**REQUEST**

Current Zoning: CG (general commercial)  
Proposed Zoning: MUDD-O (mixed use development district, optional)

Approximately 1.63 acres located along the northeast side of East 7th Street, south of Lamar Avenue, and north of Clement Avenue.

The petition proposes a multi-family residential development with some non-residential uses on an assemblage of parcels that are currently vacant.

EXISTING CONDITIONS PLAN

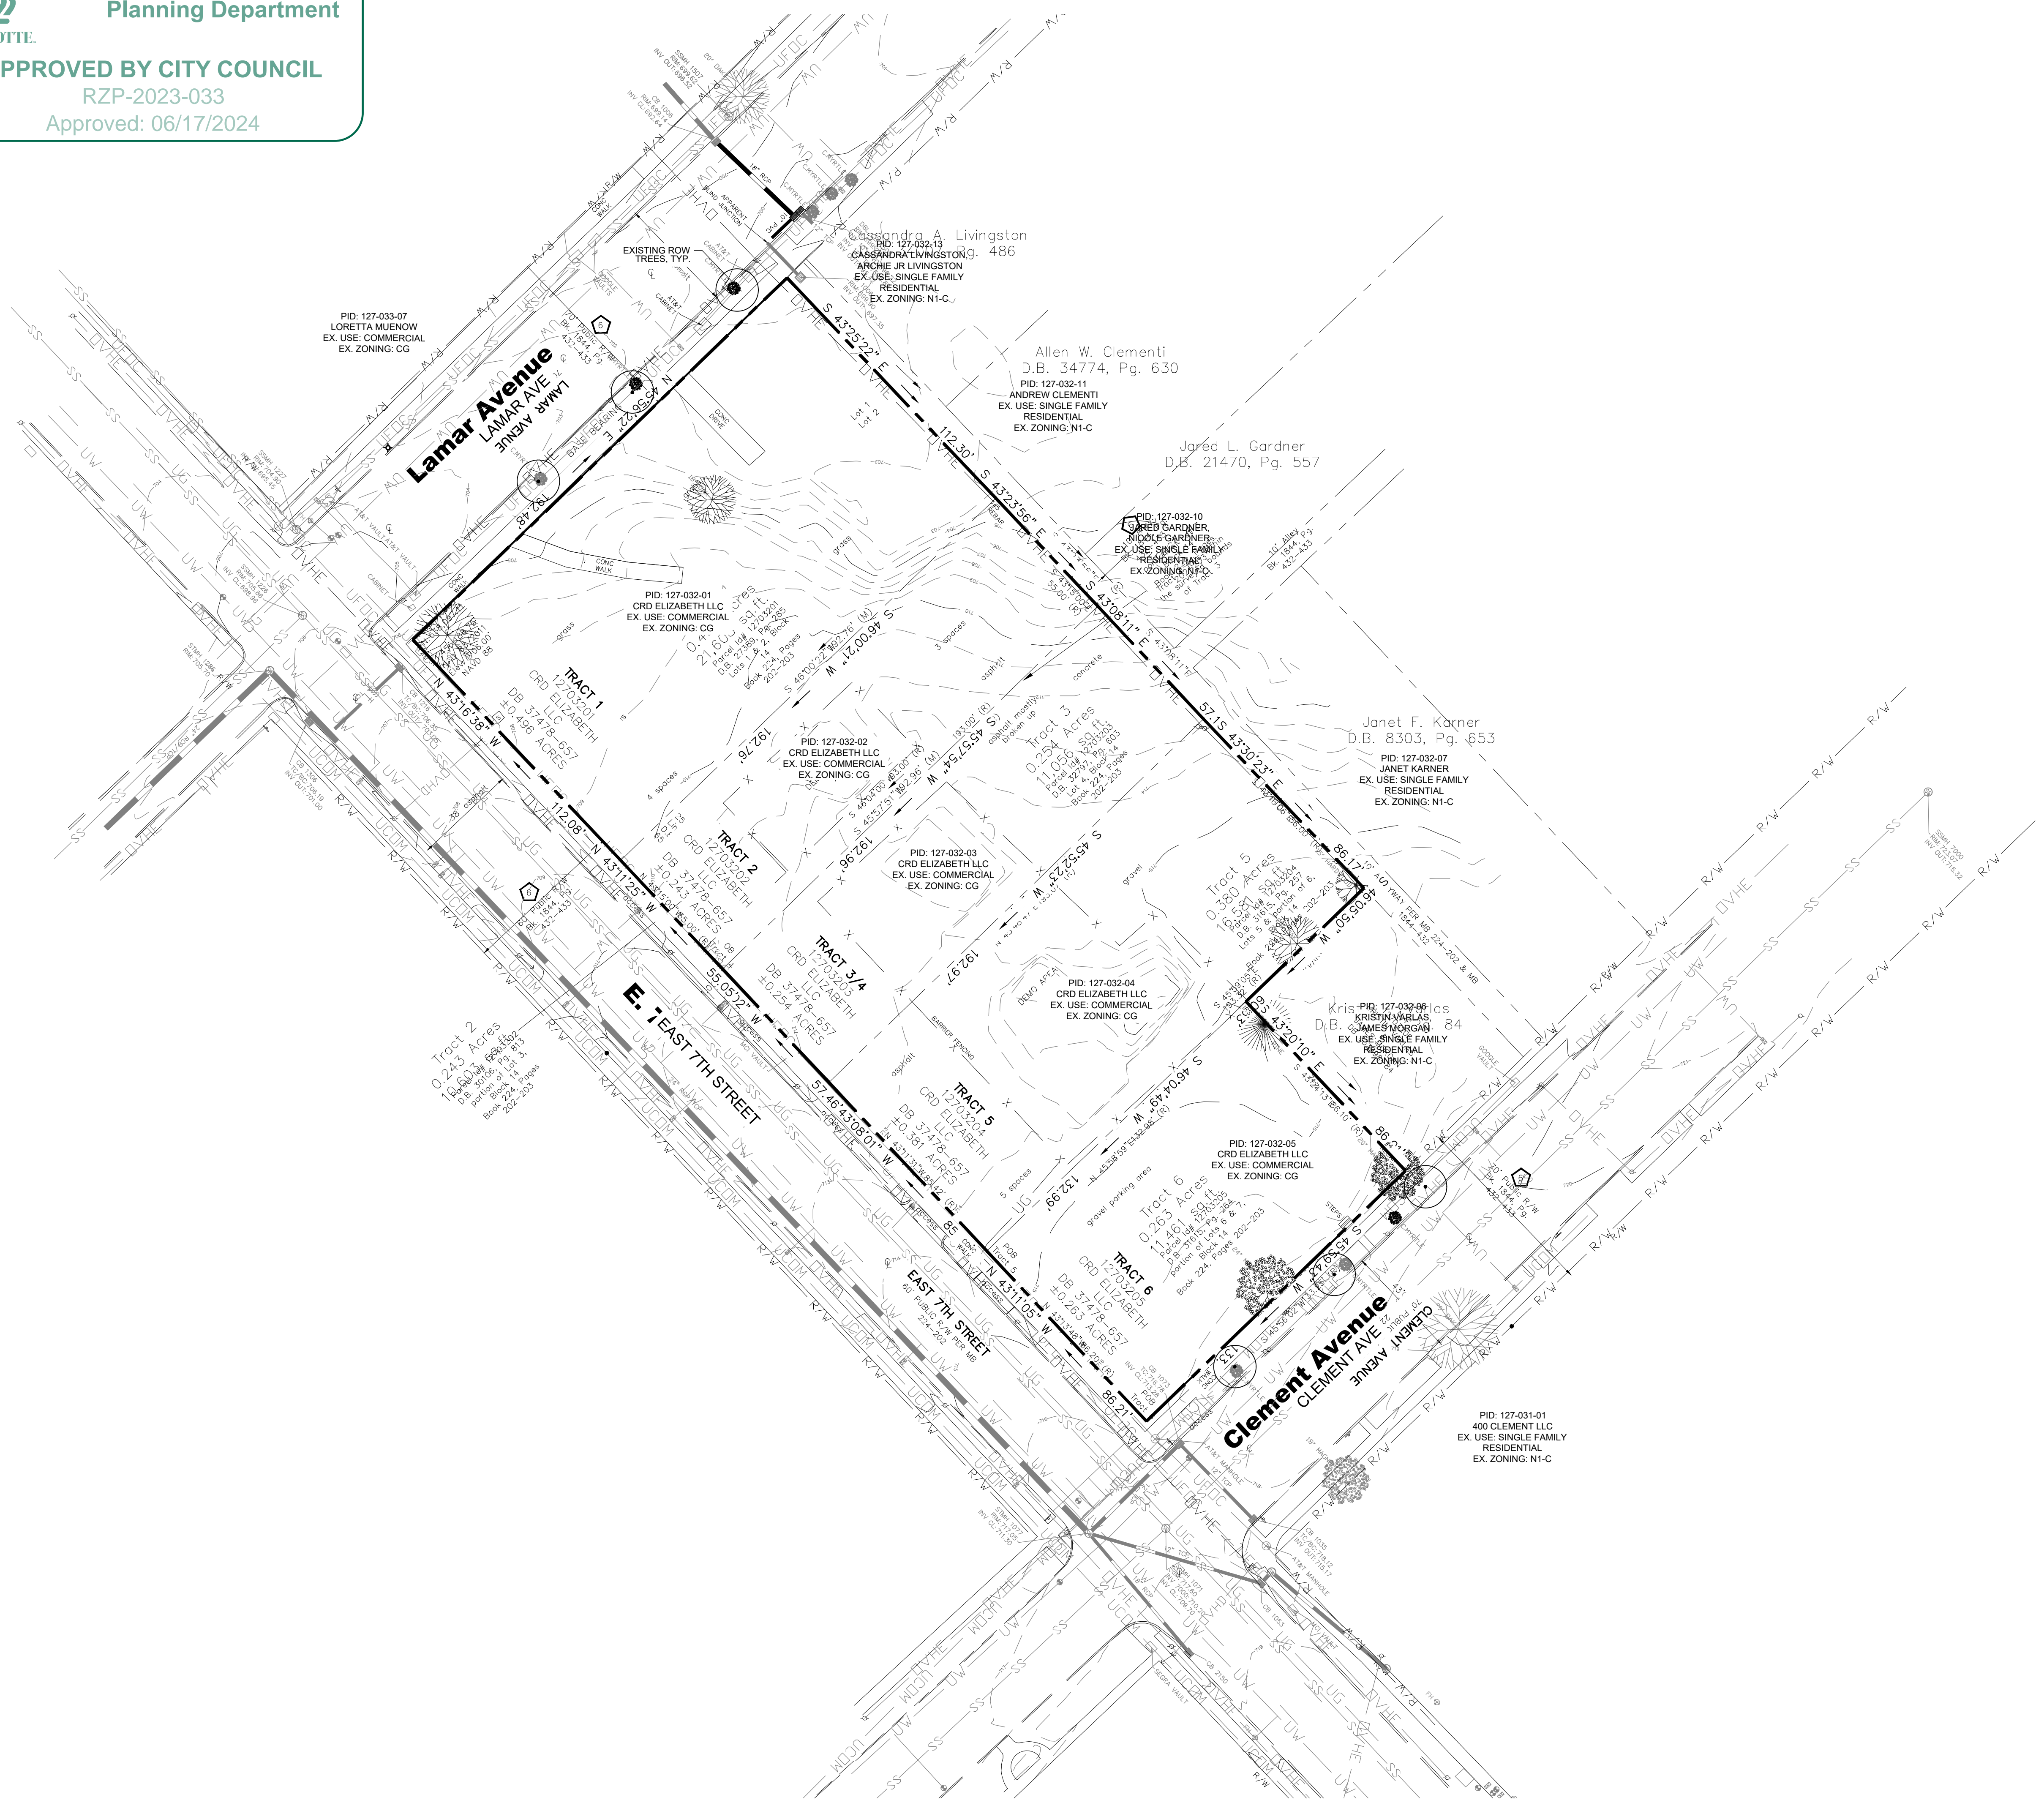
3. Modify the sidewalk and the 2' behind the sidewalk to be located within the ROW or sidewalk utility easement. If the existing ROW is remaining on Lamar and Clement Avenue, then add sidewalk utility easement to encapsulate the sidewalk plus the 2'. **Addressed**

- Provides an 8' planting strip and 8' sidewalk along all three frontages.
- Commits to upgrade the rapid flashing beacon pedestrian crossing at Clement Avenue and East 7<sup>th</sup> Street or providing an upgraded pedestrian crossing at Lamar Avenue and East 7<sup>th</sup> Street.

HEIGHT PLANE EXHIBITS

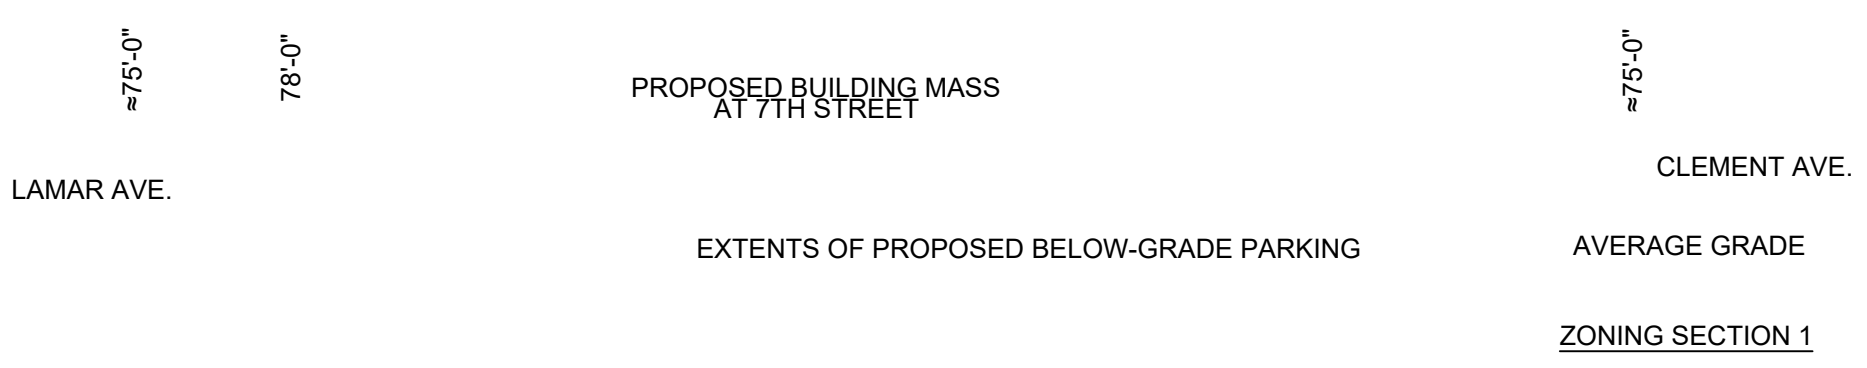
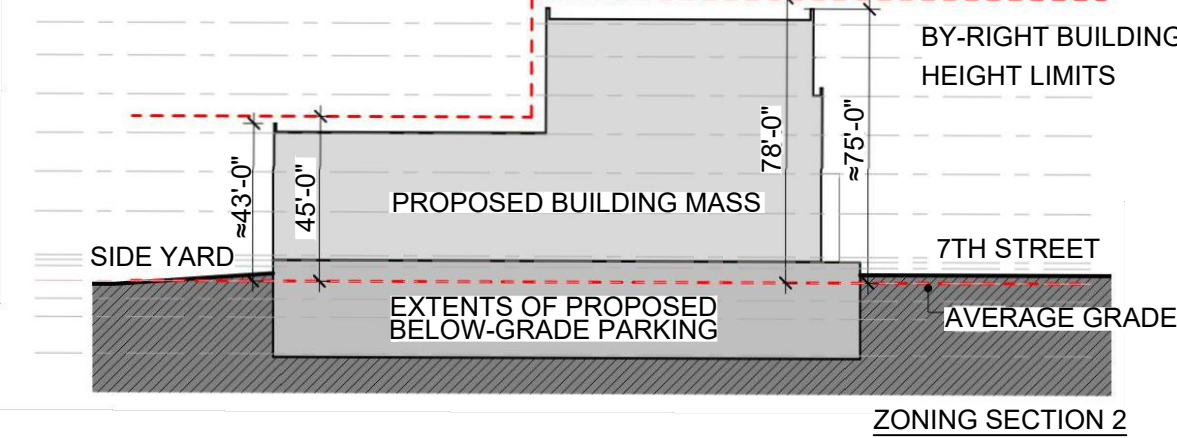
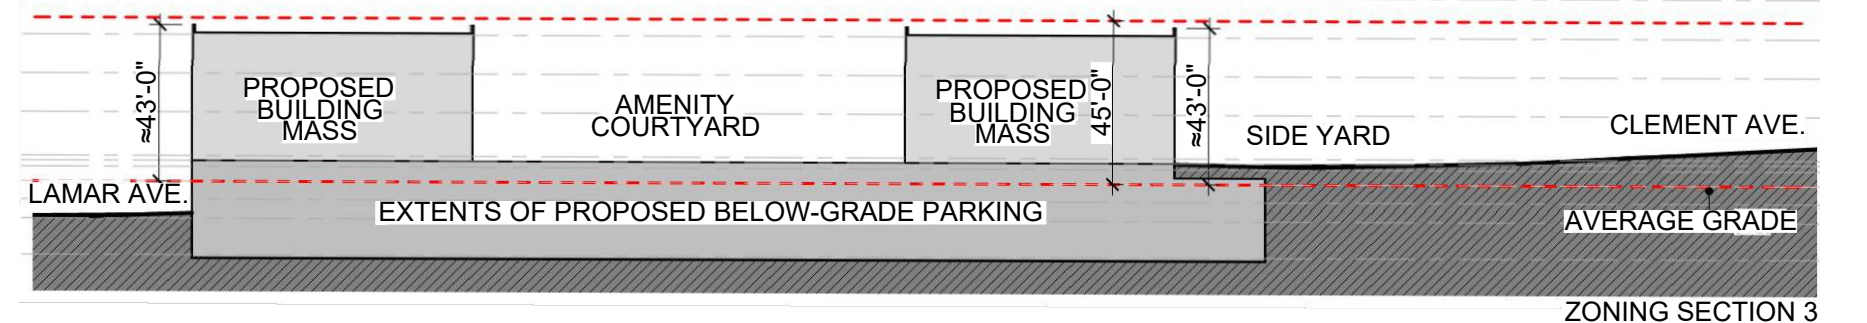
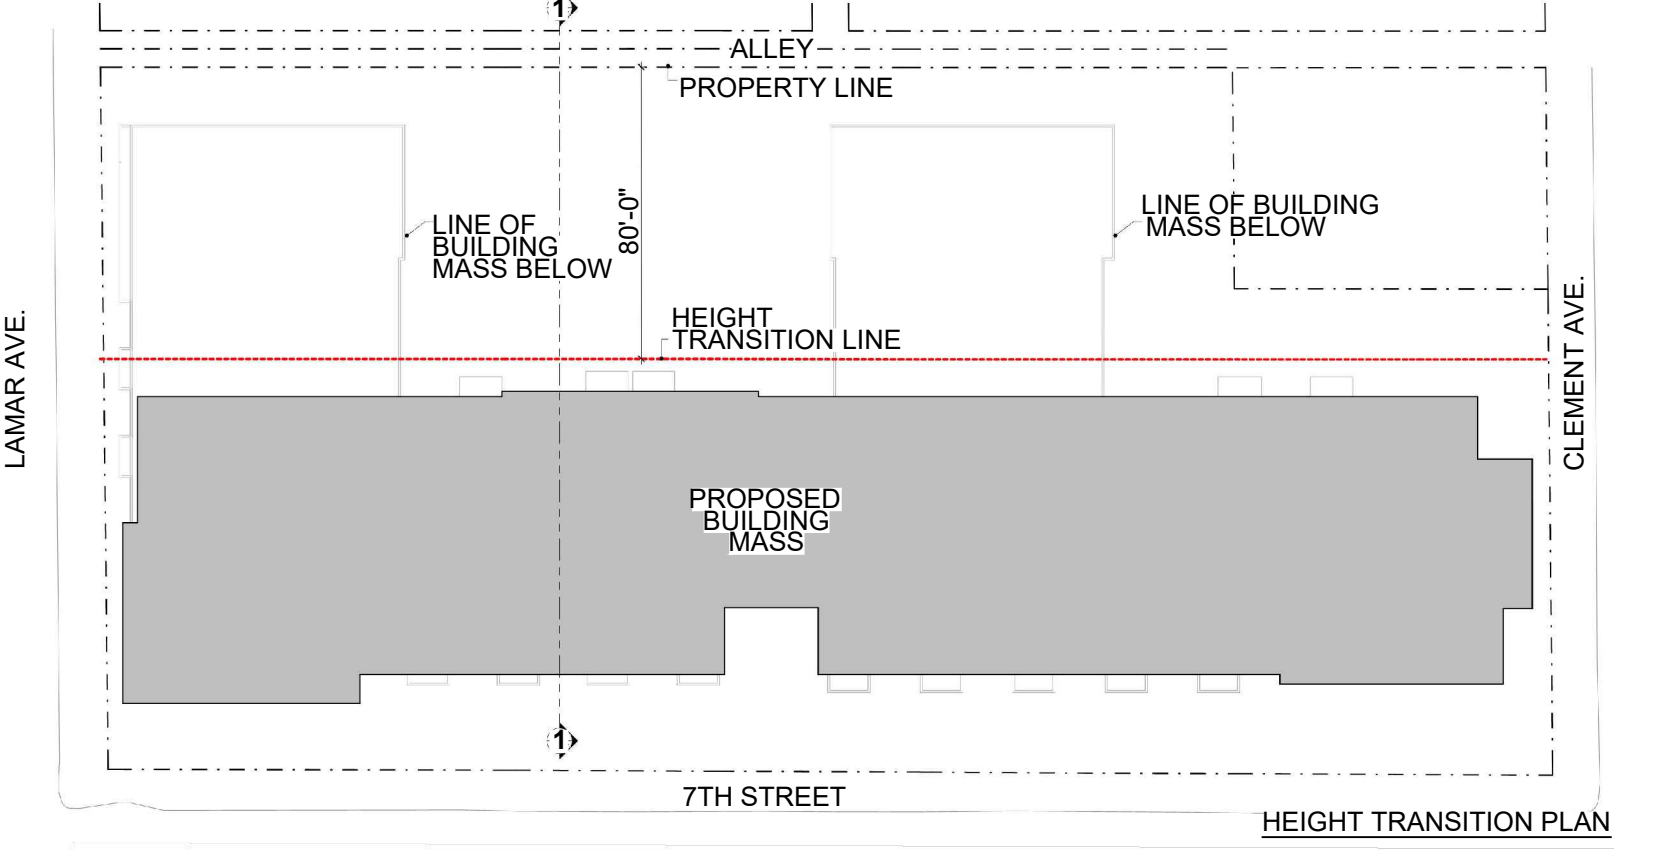
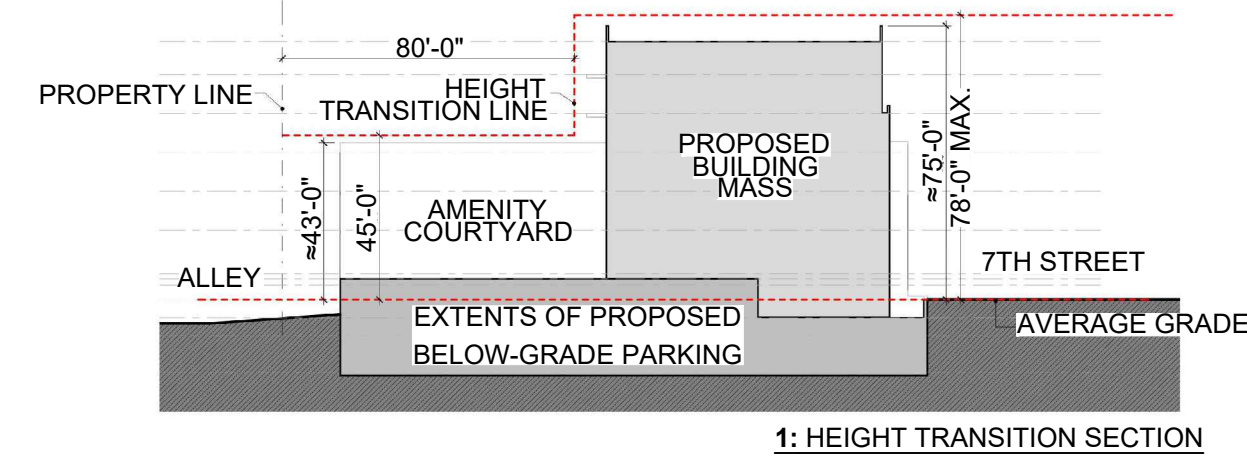
5. Reduce the maximum building height to 65' and revise the proposed height transition detailed in the height plane exhibits and conditional notes so that no portion of the proposed building exceeds 50' in height when located within 100' of property lines in the Neighborhood 1 Place Type. **Addressed**

- Proposes a maximum building height of 78', with a stepdown in height at the rear of the proposed building where the site is adjacent to single family uses. The rear of the site closest to single family homes will be a maximum height of 45'. This height stepdown to 45' will extend for a minimum of 80' into the site as measured from the rear property line.
